**KIRKLEES METROPOLITAN COUNCIL  
INVESTMENT & REGENERATION SERVICE**

**DELEGATED DECISION TO DETERMINE PLANNING APPLICATIONS**

Reference No:	<b>2023/62/90738/E</b>
Site Address:	33, Owl Lane, Shaw Cross, Dewsbury, WF12 7RG
Description:	Demolition of existing dwelling and erection of detached dwelling with integral garage
Recommending Officer:	Edward Cheseldine

## **Officer Report**

Site Block Plan 1:500

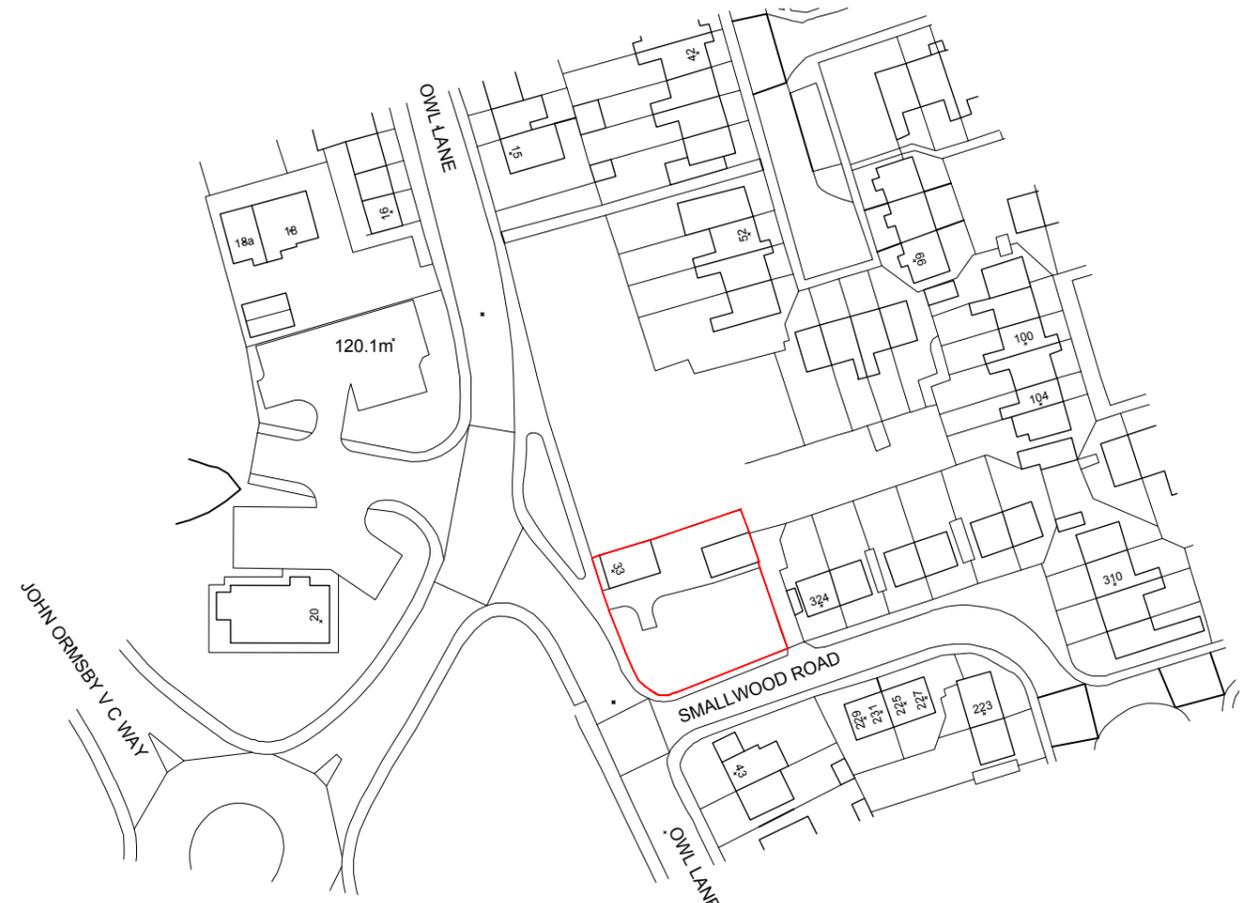
The siting of the dwelling would be towards the front of the north boundary of the site, running from the entranceway off Owl Lane towards the rear of the plot. There is a strong existing building line running from Owl Lane and Smallwood Road that the dwelling would detract from due to its position. The dwelling would run along the north-west wall at a height of ~5.60m and width of ~19.90m, which would dominate the views when travelling south on Owl

Lane. There would also be a dominating effect as public green space lies beyond this section of the site. The adjoined garage similarly does not follow these building lines. The proposal would result in a good size garden to the south of the plot, as well as incorporating parking. Because of the positioning of the dwelling, coupled with the high boundary wall, the development would result in appearing 'closed off' harming the residential character of the area, which is contributed by the size and orientation of the dwelling.

Further to the design details of the dwellinghouse, there are Officer concerns with the appropriateness of the use of land on the site. Policy LP7 of the Kirklees Local Plan states housing density should ensure efficient use of land, in keeping with the character of the area. The site is situated within a high-density residential area with several types of small dwellings surrounding it, thus pertaining the character of the area as small residential plots. A

Drawing Title:
Proposed Elevations
1 Of 2
 Scale: Date: Drawn: Checked:
1:100 @ A3 Feb 23 MS
 Drawing Number: Revision:
2022-639-007 A

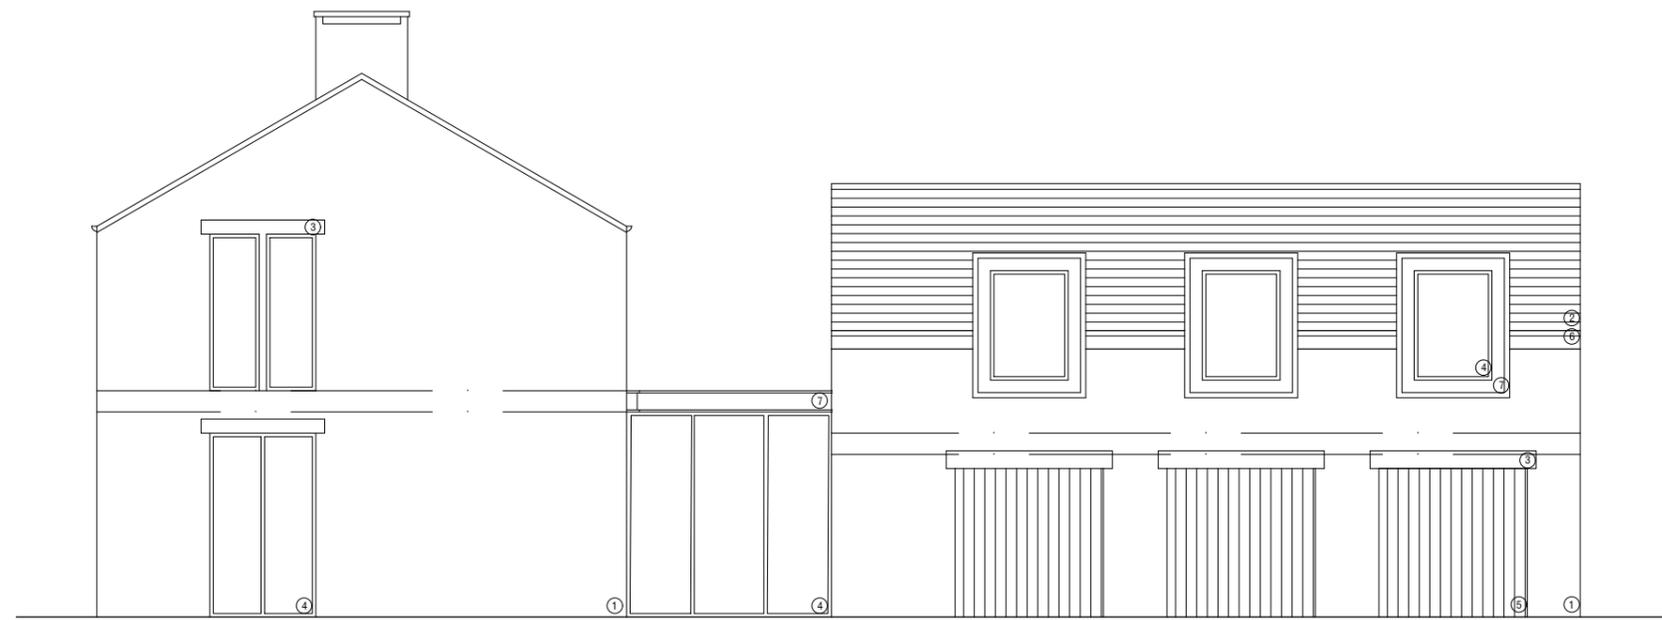
A two-storey dwelling is proposed which is considered to be acceptable given the nature of the surrounding dwellings in the locality. The ridge height of the dwelling is ~7.70m which will have a similar appearance to neighbouring dwellings, this is deemed acceptable because of the distance of separation between them. However, whilst the house is a similar height, the footprint and scale of the proposed dwelling is considerably larger than other residential dwellings in the immediate vicinity. The 'L' shape appearance of the joint dwellinghouse and garage would appear as dominant within the streetscape due to its bulk and mass. This will be amplified due to the prominence of the corner plot. The plot size is generous, and the dwelling would not appear cramped, however the north elevation of the property is set close to the boundary wall which is cramped within its locality.

Moving on to appearance, dwellings on Owl Lane and Smallwood Road are modest, rectangular builds featuring stone and brick materials. The application proposes stone walls under a slate roof, and such materials are considered acceptable in this location in principle. There is a high concentration of glazing on the south and north elevations, including the use of floor to ceiling windows. Such high amounts of glazed openings are not presently found on the surrounding buildings or within the neighbouring dwellings. The appearance of these opening does not form a coherent pattern, especially on the north elevation. Due to the positioning of the garage, the front elevation would appear from the public domain as the principal elevation. Such a large garage would negatively detract from the character of Owl Lane due to the appearance of the triple garage.
